Rezoning Transportation Analysis

Petition Number: Insert Zoning Petition #2021-264

Revision Log:

Date	Description
04-28-22	First Review (PDM)
5-25-22	Second Review (TM)

SHEET DESCRIPTION: CONDITIONAL USE PLAN
 C-1

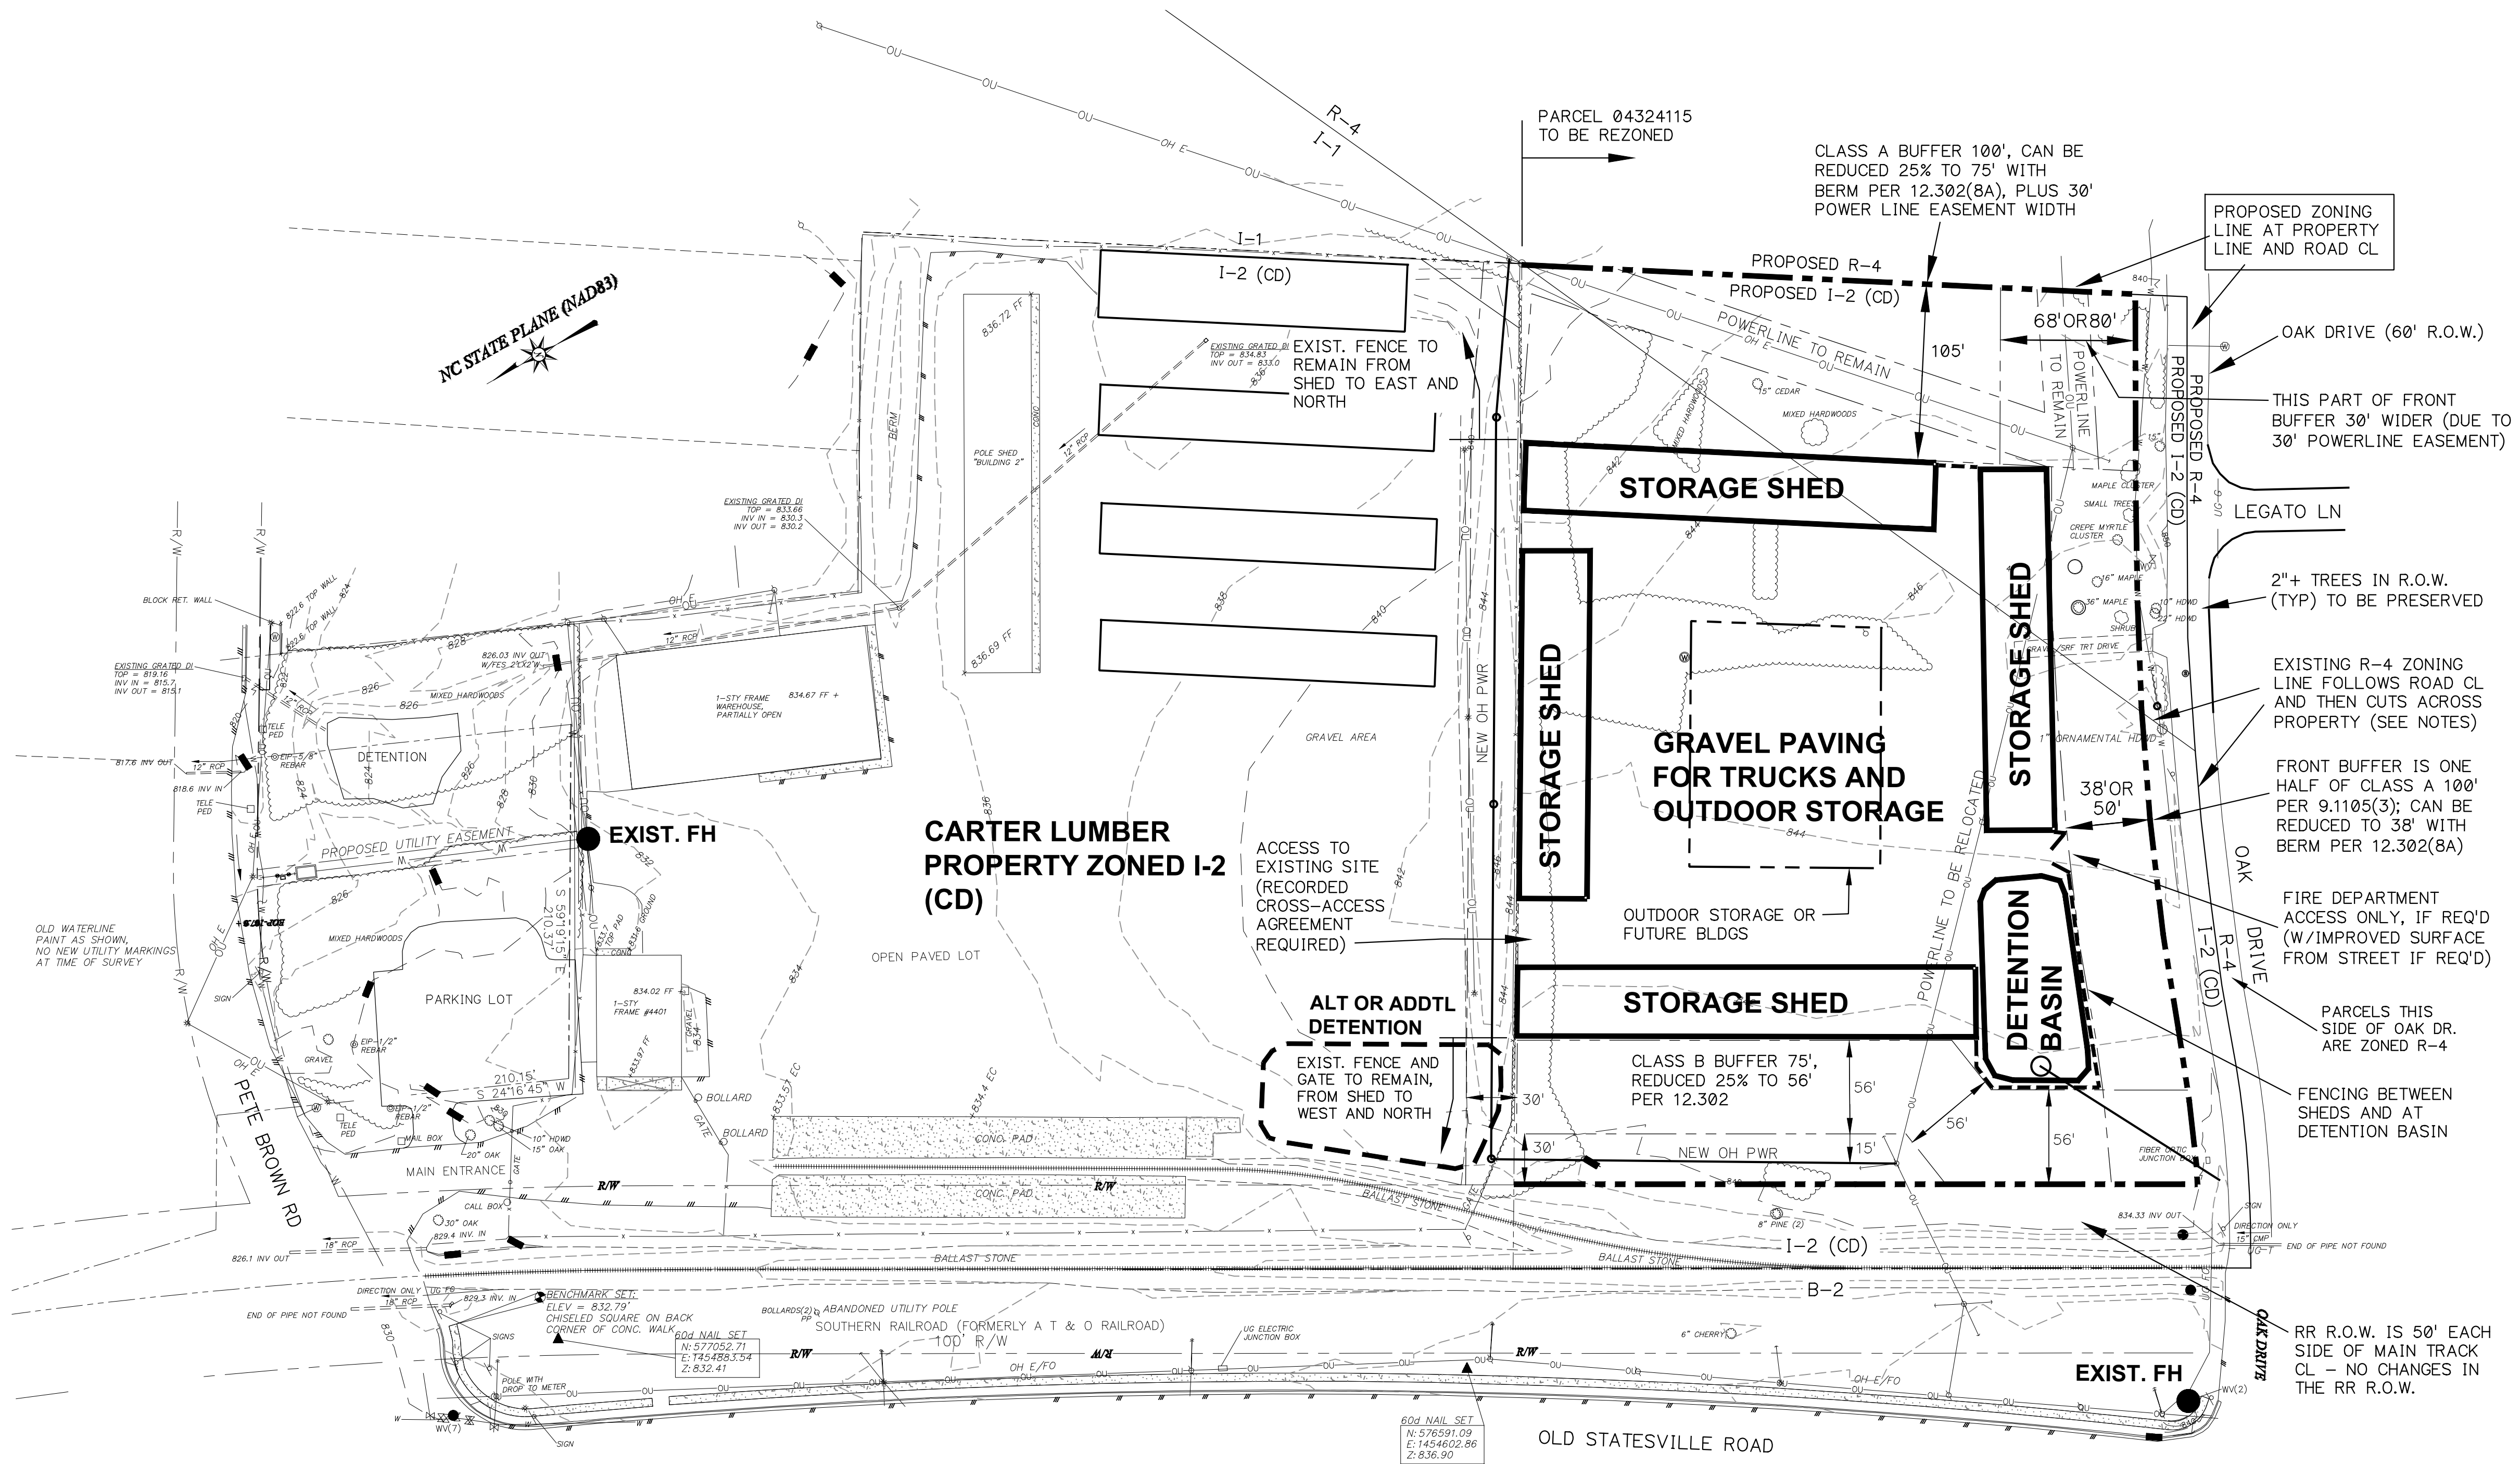
6. Site plan revisions are needed to show the location of the railroad ROW. The existing callout on the plan does not point to any linework on the site plan.

7. **Outstanding Comment from 04.28.22:** Site plan and conditional note(s) revisions are needed to clarify how the proposed access point on Oak Drive will be restricted to Fire Department access only. In addition, revise site plan to show how the driveway will access the public road. Coordinate with Charlotte FIRE to determine if this access needs to meet fire apparatus road requirements.
8. **Outstanding Comment from 04.28.22:** Site plan and conditional note(s) revisions are needed to clarify what is happening to the existing gravel driveway on Oak Drive that accesses the site. If the driveway will be closed as part of the project, add a callout to remove the driveway.

9. Add note if additional ROW will be dedicated on Oak Drive. A site plan note(s) specifying dedication and fee simple conveyance of all rights-of-way to the City before the site's first building certificate of occupancy is issued as needed. CDOT requests rights-of-way set at 2' behind back of sidewalk where feasible.
10. **Outstanding Comment from 04.28.22:** A site plan note specifying that all transportation improvements will be approved and constructed before the site's first building certificate of occupancy is issued as needed. The petitioner may phase transportation improvements if said improvements and phasing are explicitly described in site plan notes.
